## 42 OBrion St - permit #01825

**Christina Stacey** <cstacey@portlandmaine.gov>  
To: jason@portcityarch.com

**Jason Pica** <jason@portcityarch.com>  
To: Christina Stacey <cstacey@portlandmaine.gov>

### ELEVATIONS

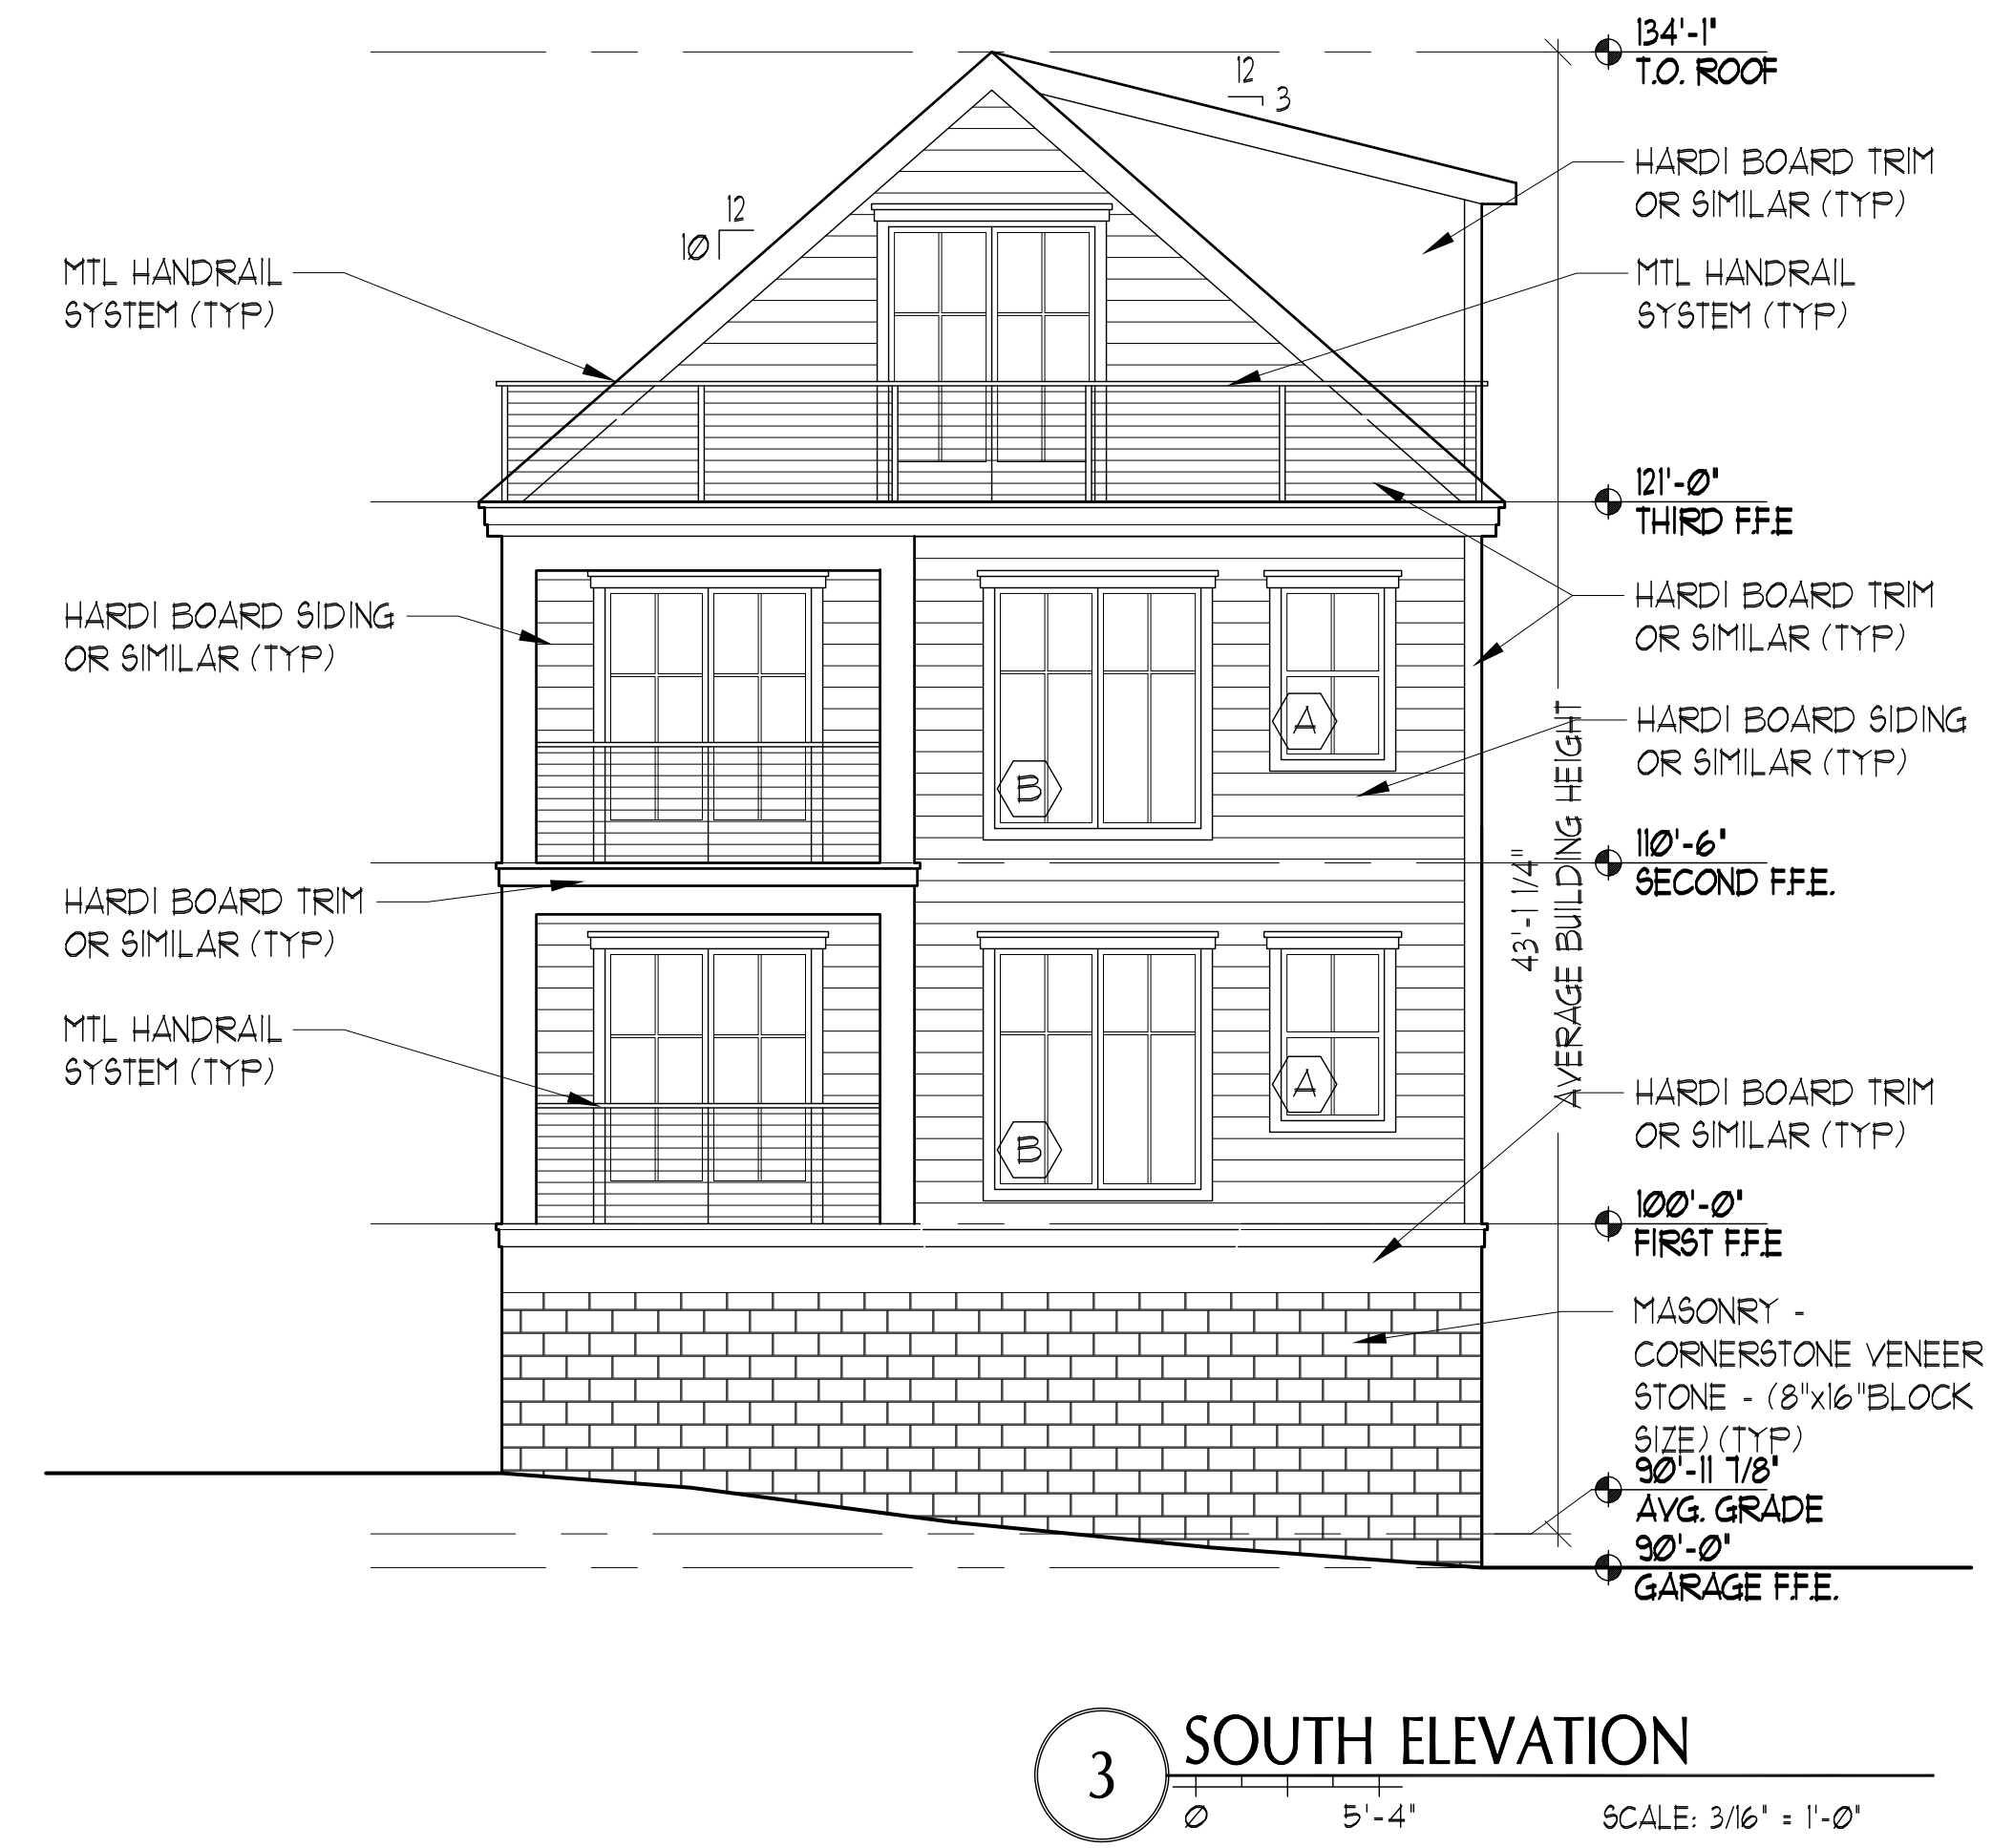
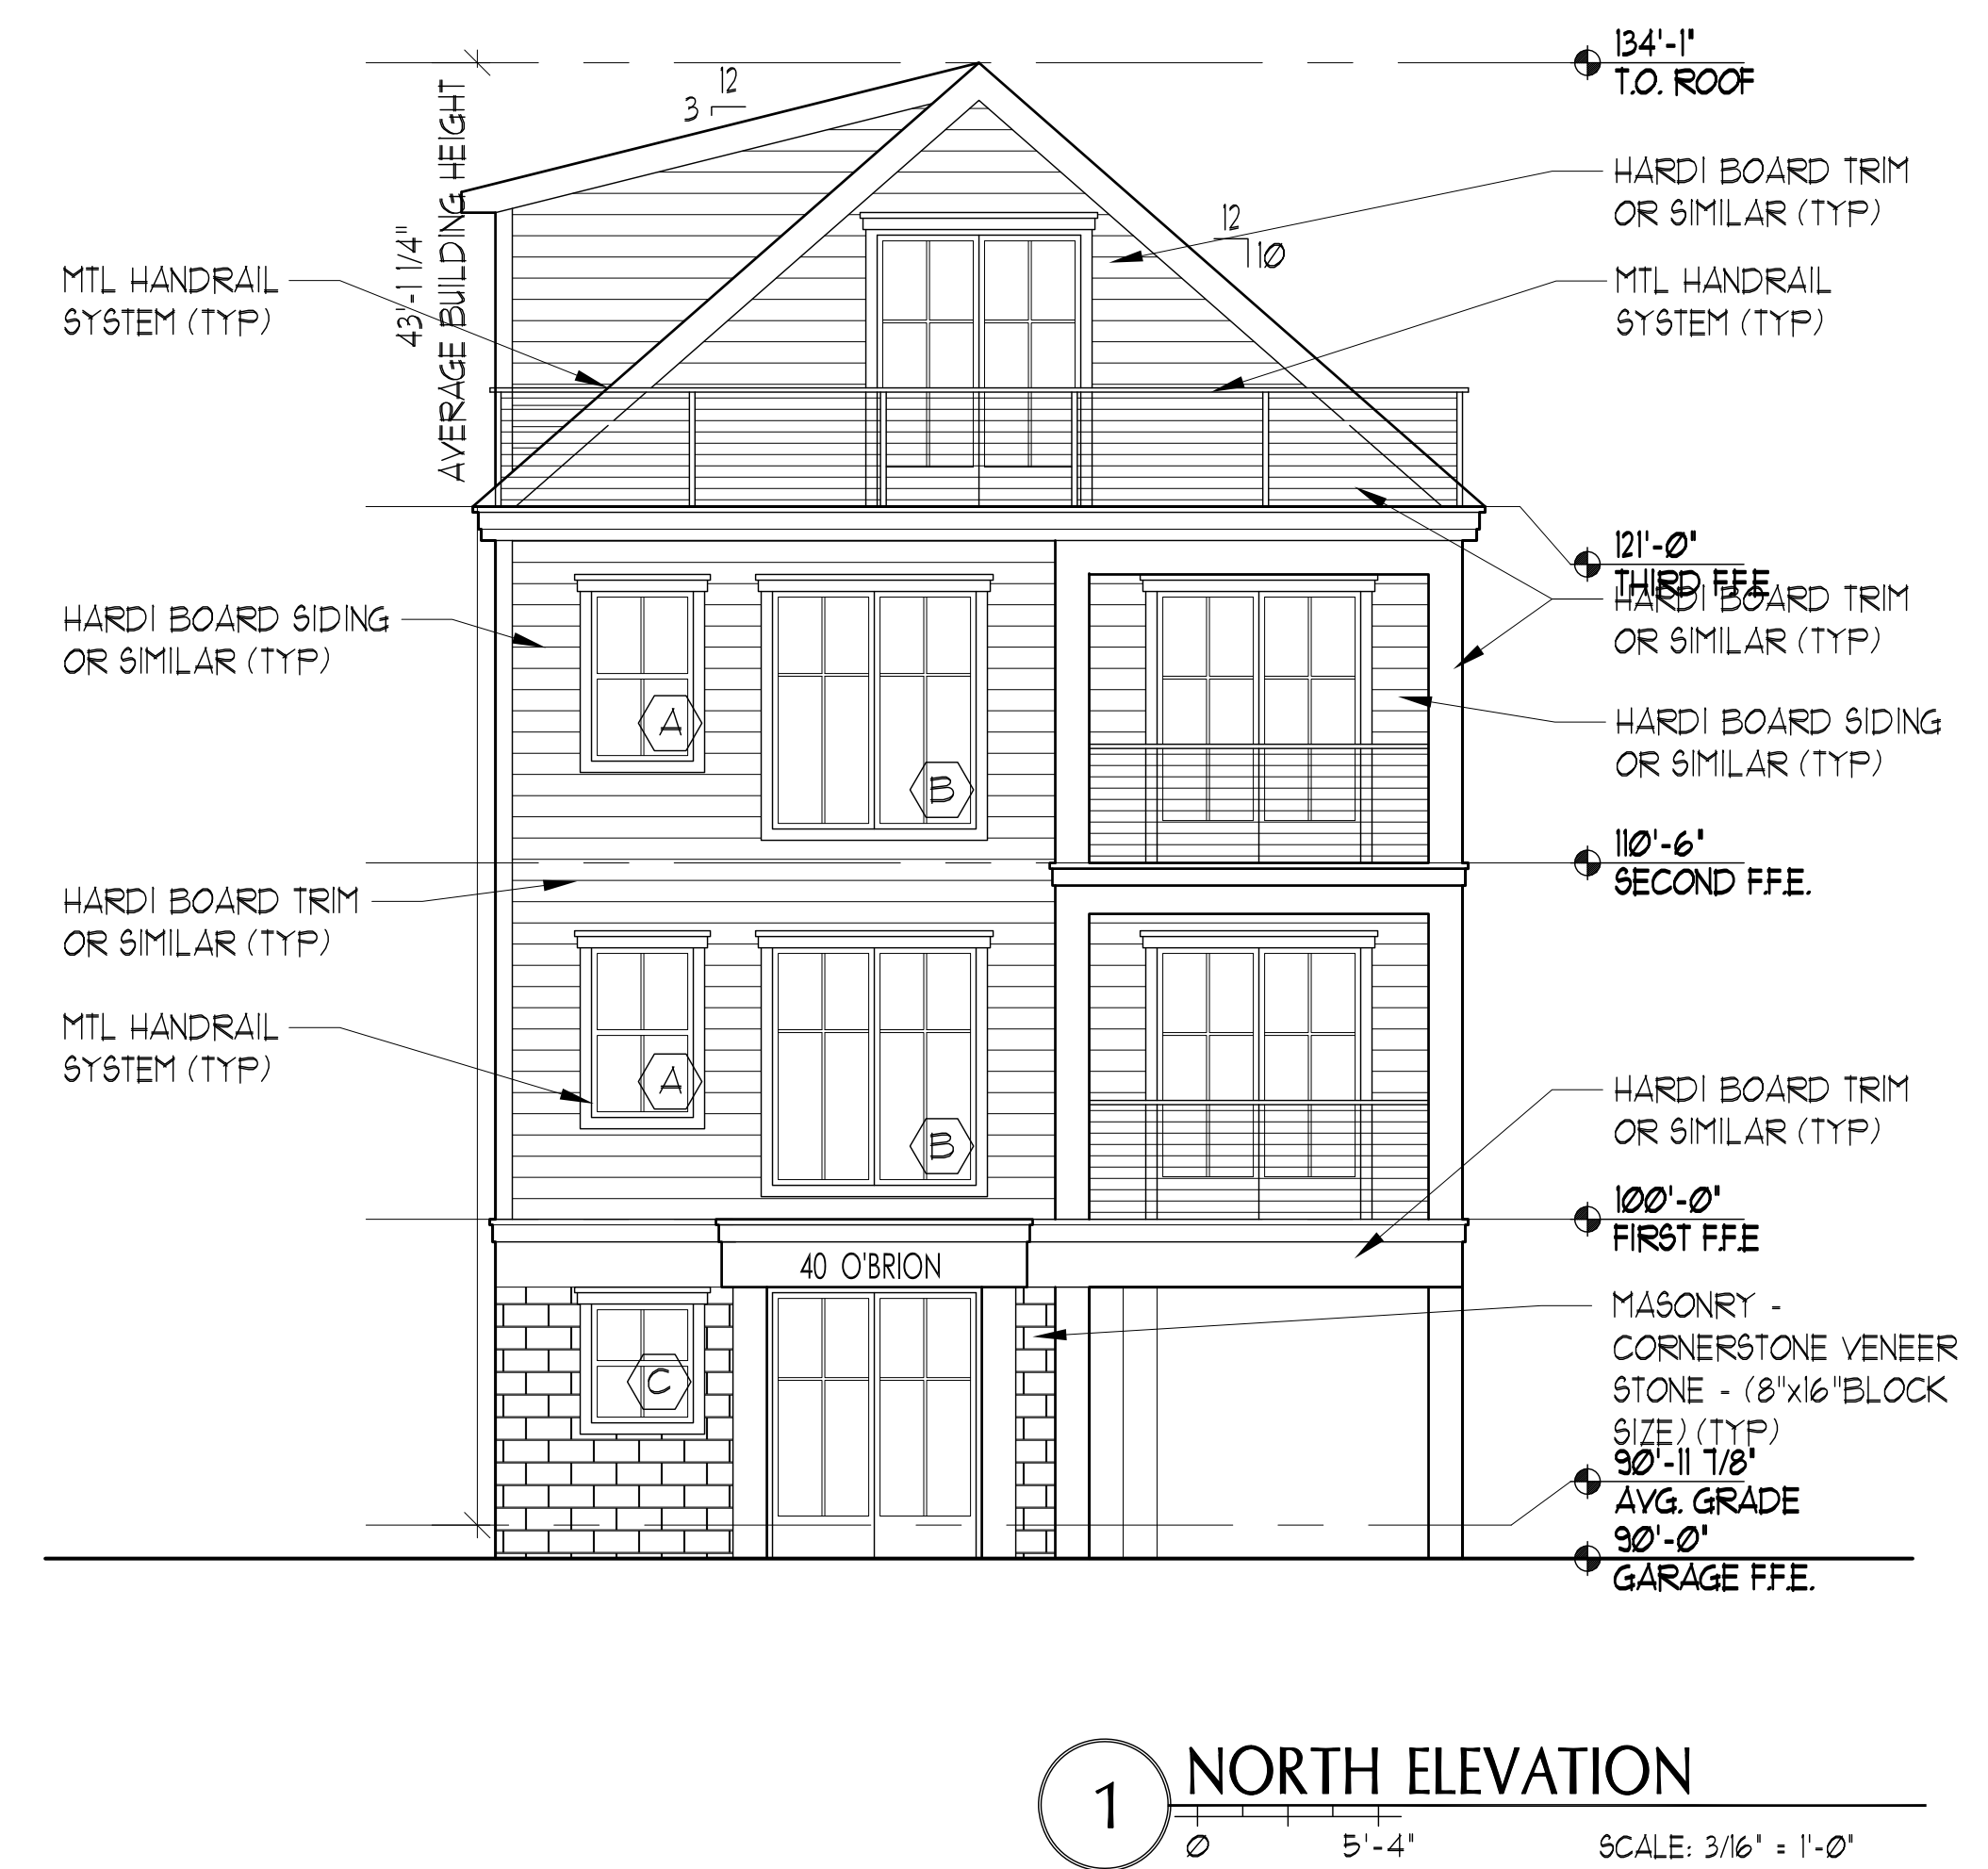
Thanks for chatting about my questions. As I mentioned, I am concerned that the gabled roof will not meet the side stepback requirement (or at least my previous understanding of that requirement). You mentioned that you recall other project(s) that allowed gabled roofs to meet the stepback - if you can provide any addresses so I can look at the permit history, that would be helpful.

Also, if you can just confirm in writing that the average grade shown on the elevations is correct and based on the civil drawing, I would appreciate it!

Yes, the small corner you depict on the NW roof side is one area of concern. The dormer on the opposite side is of concern too. Your e-mail alludes to Section 14-430, which exempts from the height limitation "roof structures for the housing of elevators, stairways, tanks, fans, or other building operating equipment not intended for human occupancy..." We have interpreted this to mean that the structure must be of the minimum size to accommodate the stairway and that no "living space" (i.e. areas intended for human occupancy) can be part of the structure. As I said in our call, I am not aware of a dormer yet that has been approved for this purpose, so I don't have a good example to go by. I did talk with the Zoning Administrator and she agreed that one concern with dormers would be if it creates additional headroom for the purpose of increasing the overall living space of the fourth floor, in addition to accommodating the stairway. I think we it would be helpful to see an elevation view that shows the 10' stepback area marked, proving that the dormer height and volume within that stepback is the minimum needed to accommodate the stairway for code purposes. Obviously, once beyond the stepback the dormer height (as long as total under the 45' max) is not a concern. I also want to know whether the overall length of the dormer is creating additional floor area that may not be necessary to the stair access - see the approximately 4' by 6' area next to each set of stairs, towards the gable end walls.

I showed this new plan to the Zoning Administrator. She has not yet seen a dormer being used for the Section 14-430 height limit exemption, but her interpretation is that a dormer could be considered a "roof structure" as allowed under the rule. She cautions that an affected neighbor could appeal her interpretation, as historically we have only seen the exemption applied to tower-style structures.

She did ask if you can supply a cross-sectional view (from the east) demonstrating that the dormer is the absolute minimum size that would be needed to provide adequate headroom for the stairs. Specifically, she is wondering if the dormer can be narrowed further, since headroom does not necessarily need to be created for the lower part of the stairs.

I think this should work, but I have a request - I need to be able to overwrite the previous plans with new versions that are like-for-like. Is it possible to incorporate these revised views into the appropriate plans? For example, the original submission had all four elevation views on one sheet - can the new north elevation be inserted into that sheet?

Also, I can confirm that the written dimensions on the Elevations match the civil drawings and the site survey. The grade was inadvertently drawn lower than reality and the civil drawings.

Good Afternoon, See attached revised drawings that address the zoning concerns. In order to remove the gabled roof from the setback requirements over 35', we reduced the overall height of the building by 12" ( we took 6" from the floor to floors of the first and second floor), this removed all structure from the required setback. To address the opposite side of the building with the stair case, we pushed the dormered area back towards the center of the building by 6'2" and created a low headroom area to the front with same pitched roof as the opposite side which does not fall within the setback. Let me know of any other issues or concerns. Thanks

Good Afternoon, See attached for the revised drawings as well as the addition of the section showing the stair headroom. From the previous version we pushed the dormer in an additional 2'-2" to 8'4" (6'2" previously). Hope this clears it up, Thanks

Good Morning, Please see attached for the New Elevations sheet A2.1 as well as a revised A1.2 for the third floor, I added a note that the fridge would be an under counter bar fridge. Thanks
